From: Sue Howell
Sent: 06 September 2018 16:05
To: Planning.Responses
Cc: Anita Gardner
Subject: RE: Planning Consultation on LU/167/18/DOC

APPLICATION NO: LU/167/18/DOC

Registered: 01-JUN-18
Site Address: 1 Tulley Cottages Toddington Lane Littlehampton BN17 7PW

Description of Works: Approval of details reserved by condition imposed under LU/251/15/PL relating to conditions 3-schedule & samples of

Area I.

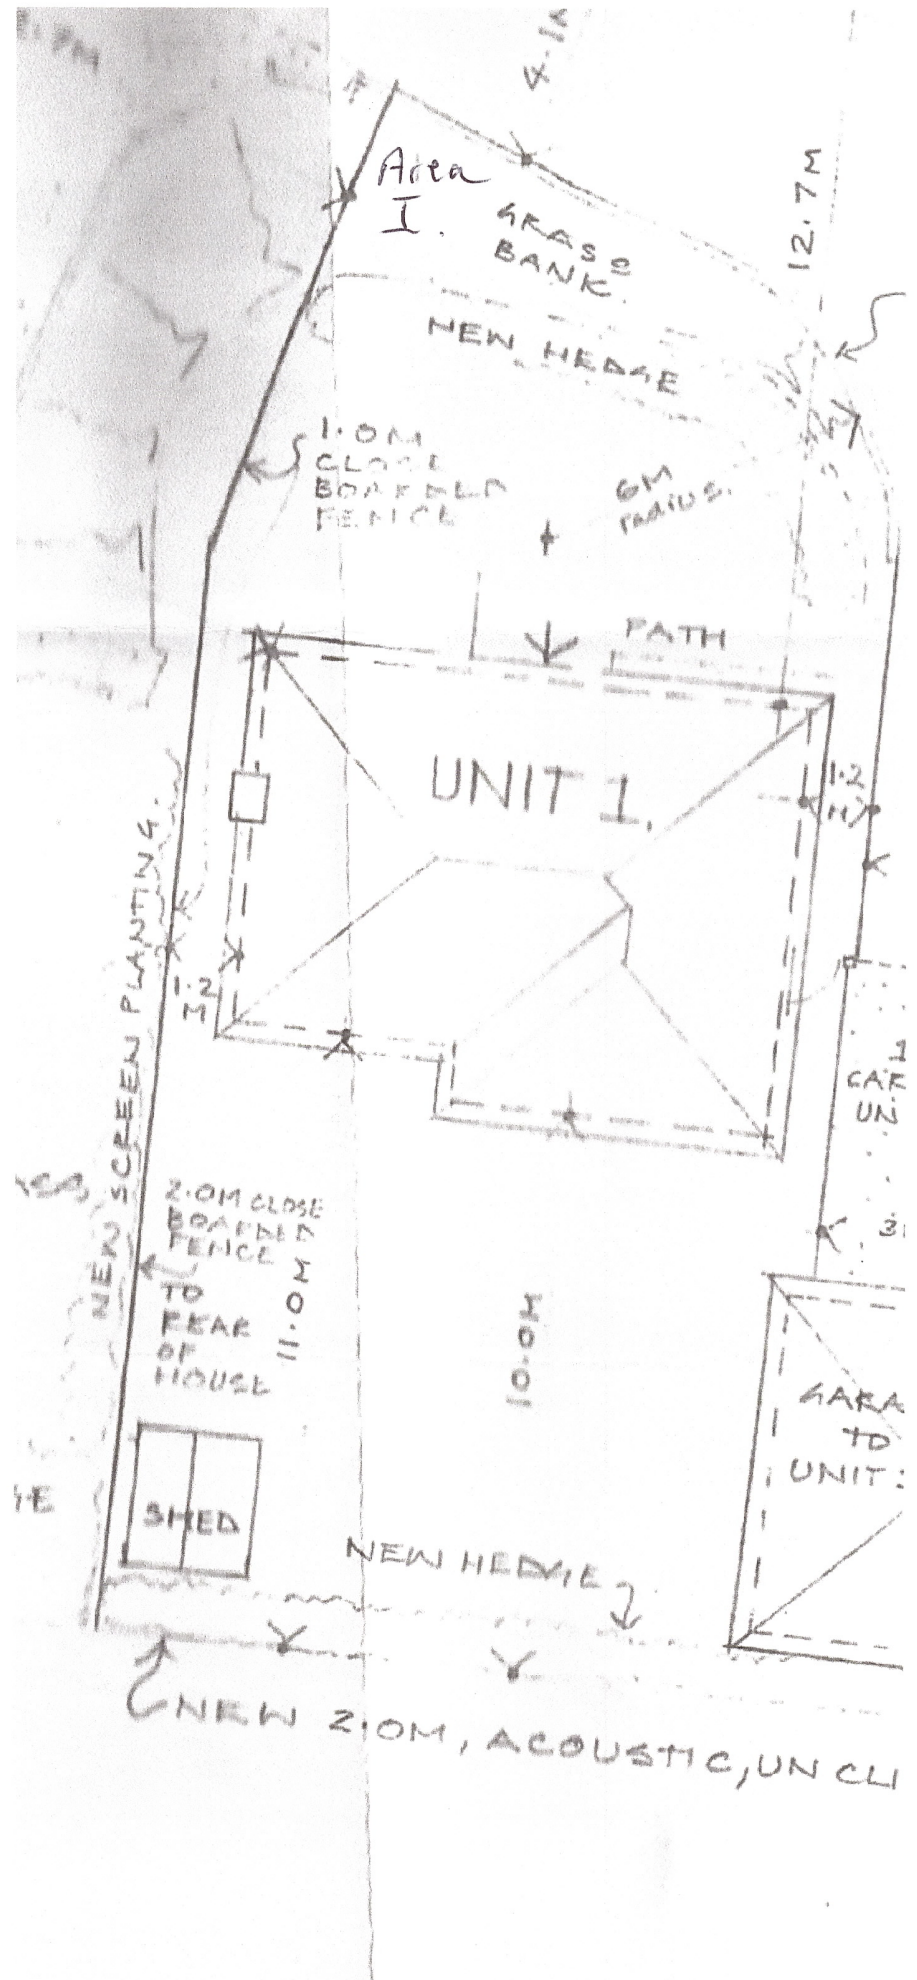
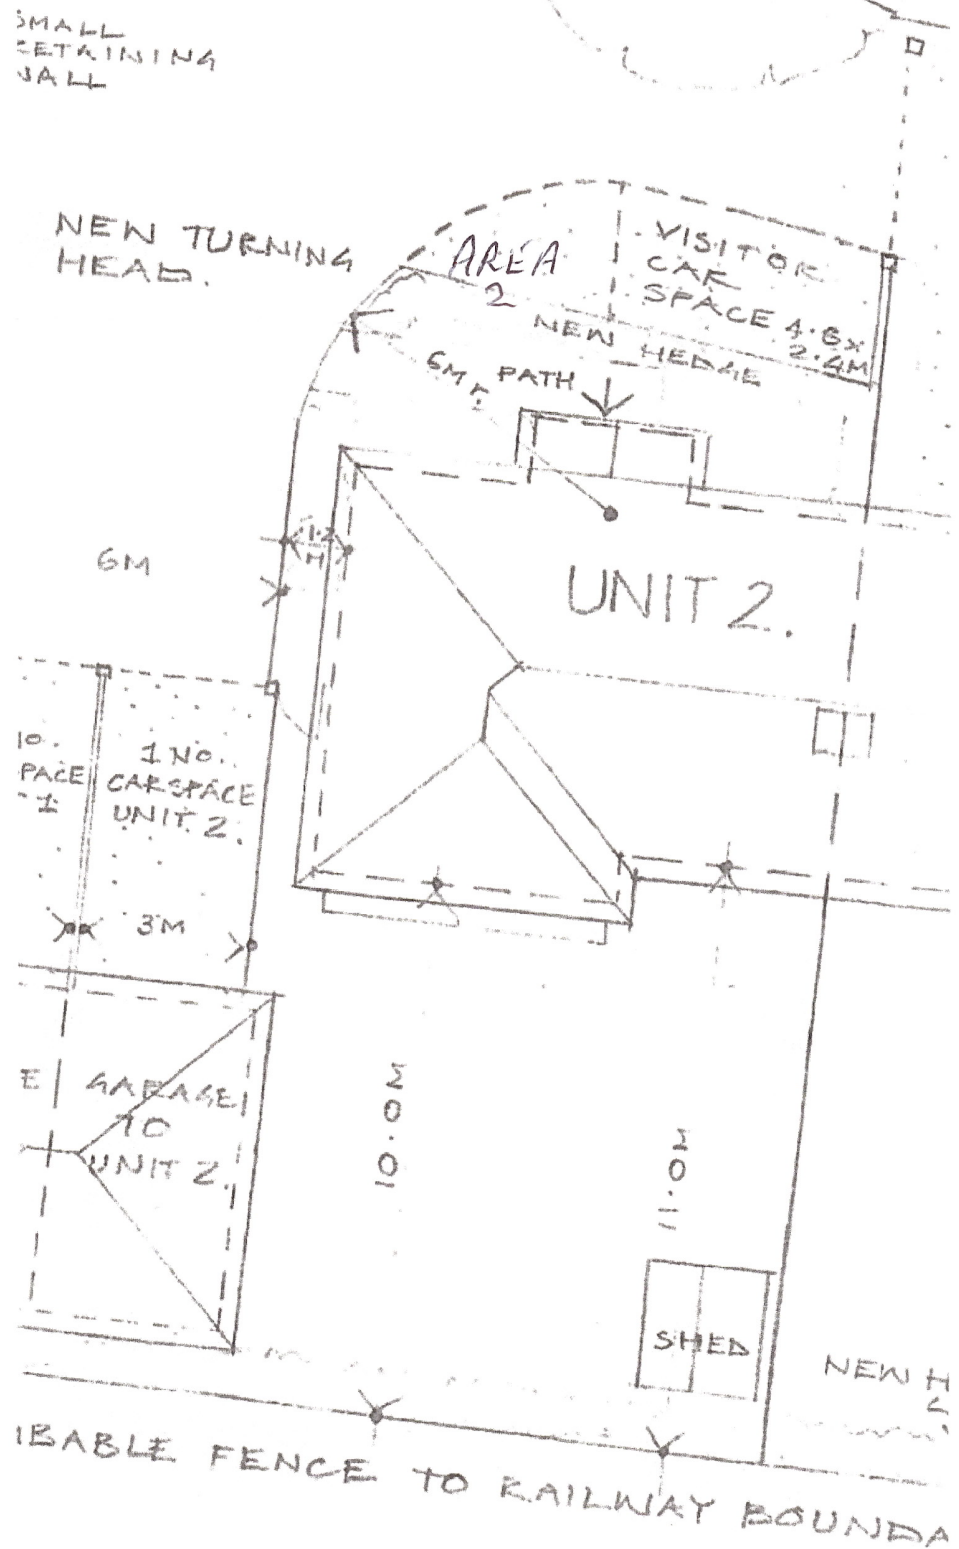
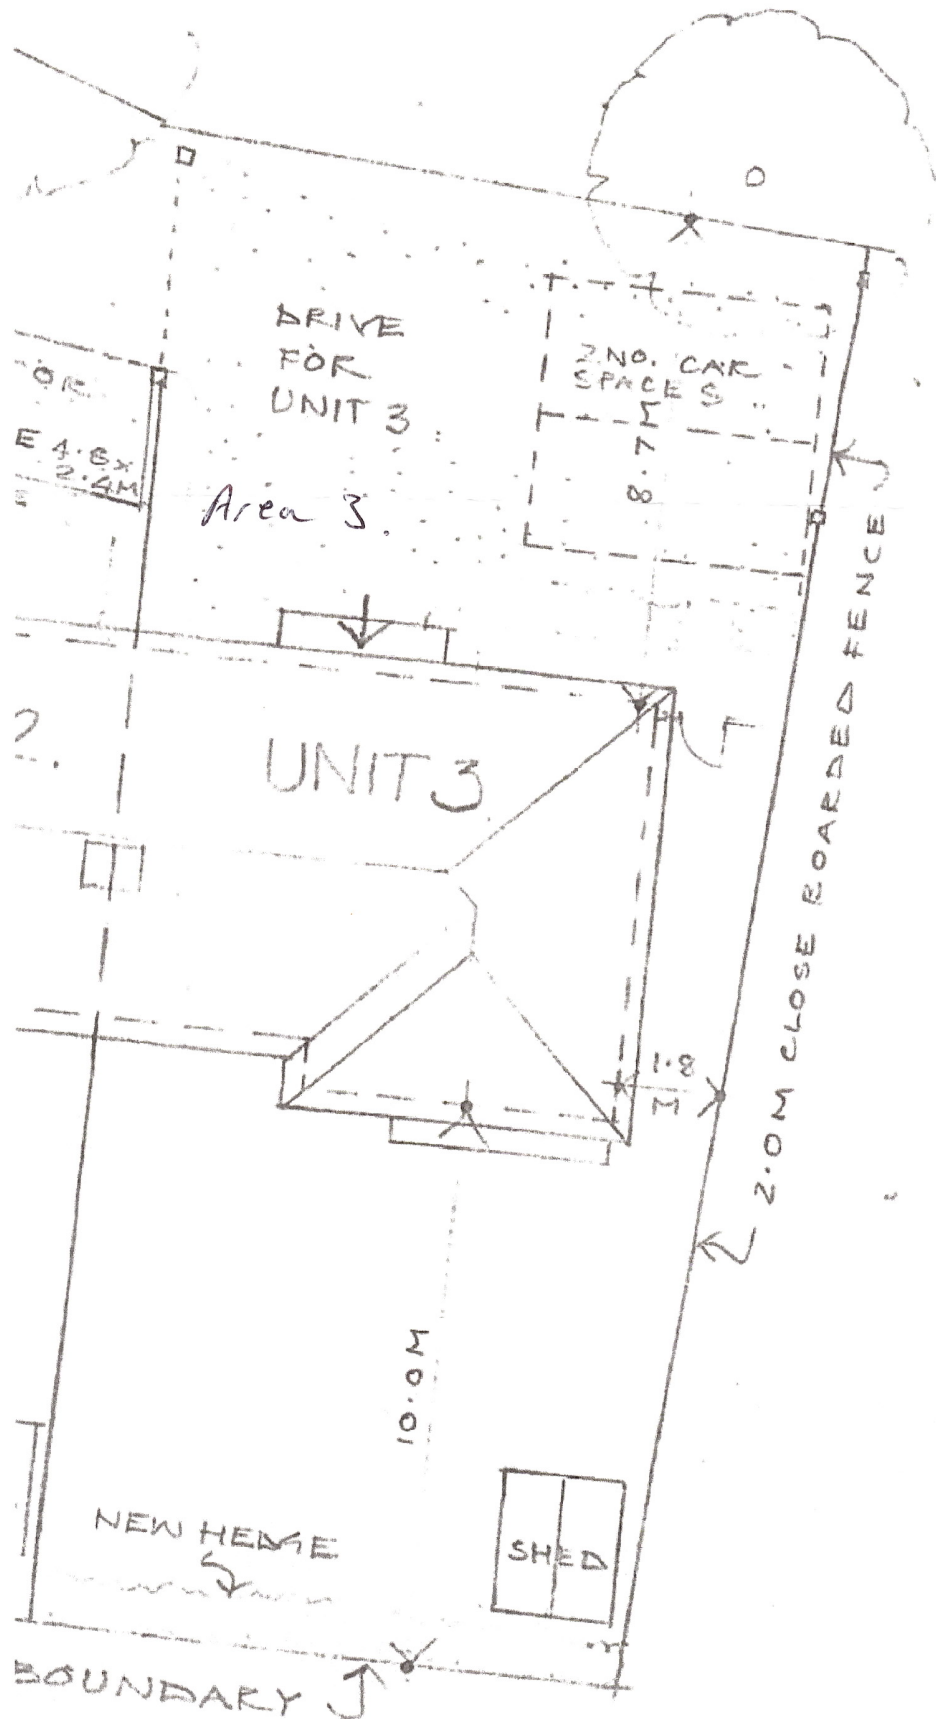
The information submitted under drawing headed Landscape Plan areas 1,2,3 does not provide clear or adequately detailed information re species choice, actual numbers proposed and size at time of planting. These need to be shown clearly indicated in the planned location areas. The drawing refers also to new hedge, which does not appear to have been detailed with the above information.

I would therefore **not recommend the discharge of condition 4** imposed under LU/251/15/PL on this application LU/167/18/DOC until the detail above has been supplied in the format requested so that a clear picture of the proposals can be seen.
